Application for removal or variation of a condition following grant of
planning permission. Town and Country Planning Act 1990.
Planning (Listed Buildings and Conservation Areas) Act 1990

House:		Suffix:	
House name:	Lefleys Garage		
Street address:	Station Road		
	Holbeach		
Town/City:	Spalding		
County:	Lincolnshire		
Postcode:	PE12 7LF

Change of use of site to Class C3 (residential), erection of 51 dwellings and conversion of Station House building to 4 dwellings.

Application reference number:	H09-0057-14	Date of decision:	26/02/2014
-------------------------------	--	-------------------	---

Project:			
Former Garage & Public House Site			
Station Road			
Holebeach			
Lincs			
Drawing Title:			
Proposed Renewable Energy			
Client:			
Haycroft Homes Ltd			
Drawn:			
AMW		Checked:	AMW
11/12/2022		Date:	24.10.13
PD24		Stage:	As shown
P2		Revision:	A1

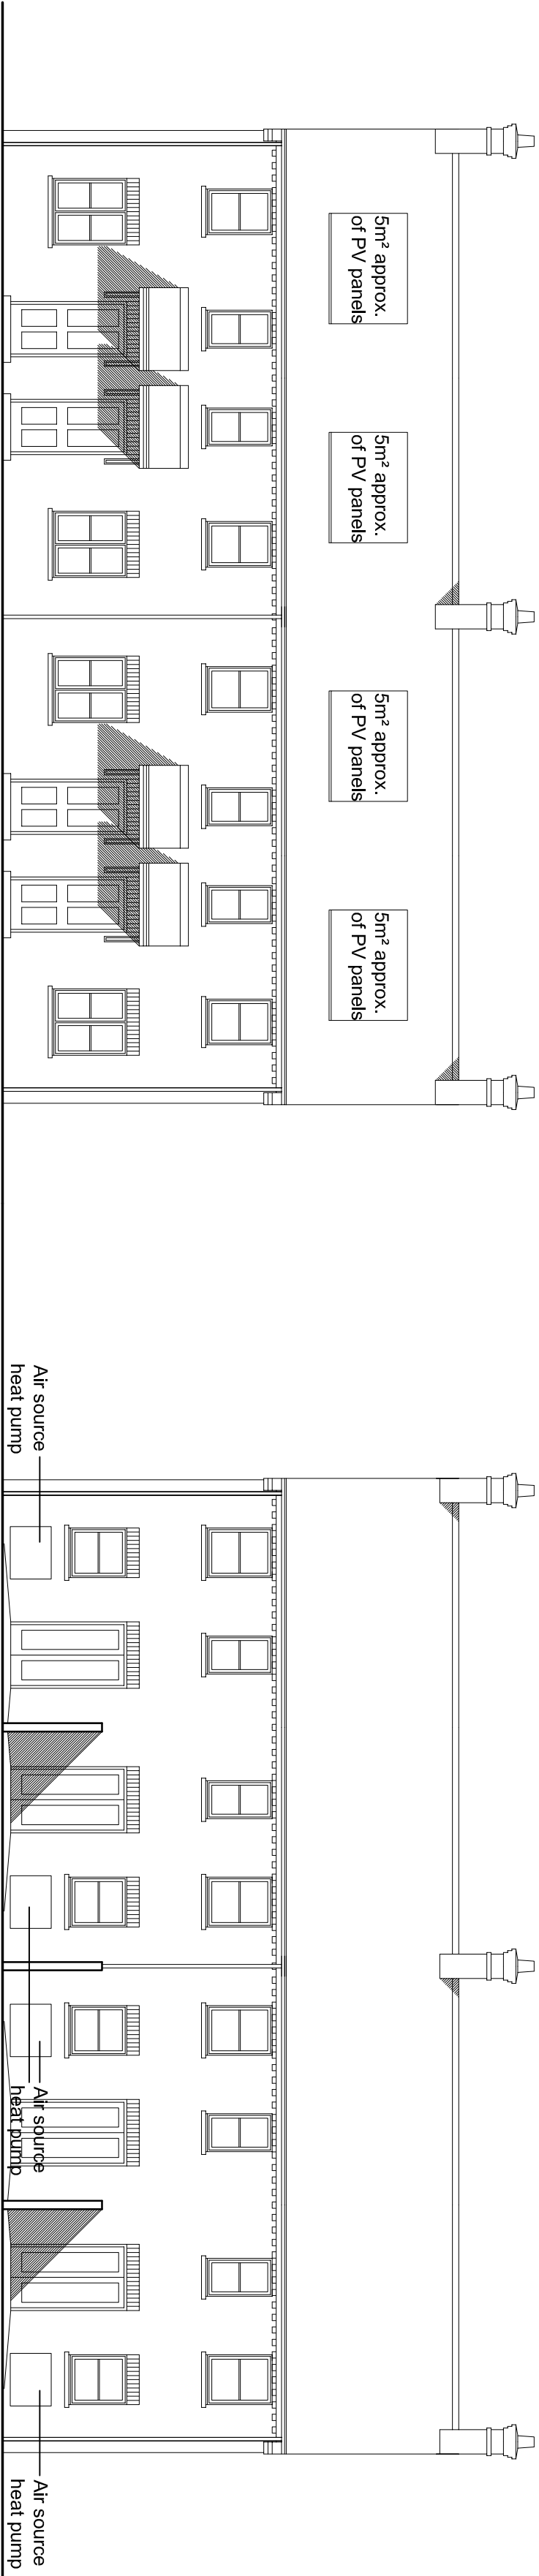
It is requested that condition 2 is changed to include drawing number PD24(P2).

This is because the renewables scheme has been revised following the previously submitted / approved scheme under H09-0962-13.

Please list/include drawing number PD24(P2) in condition 2 as an approved plan.
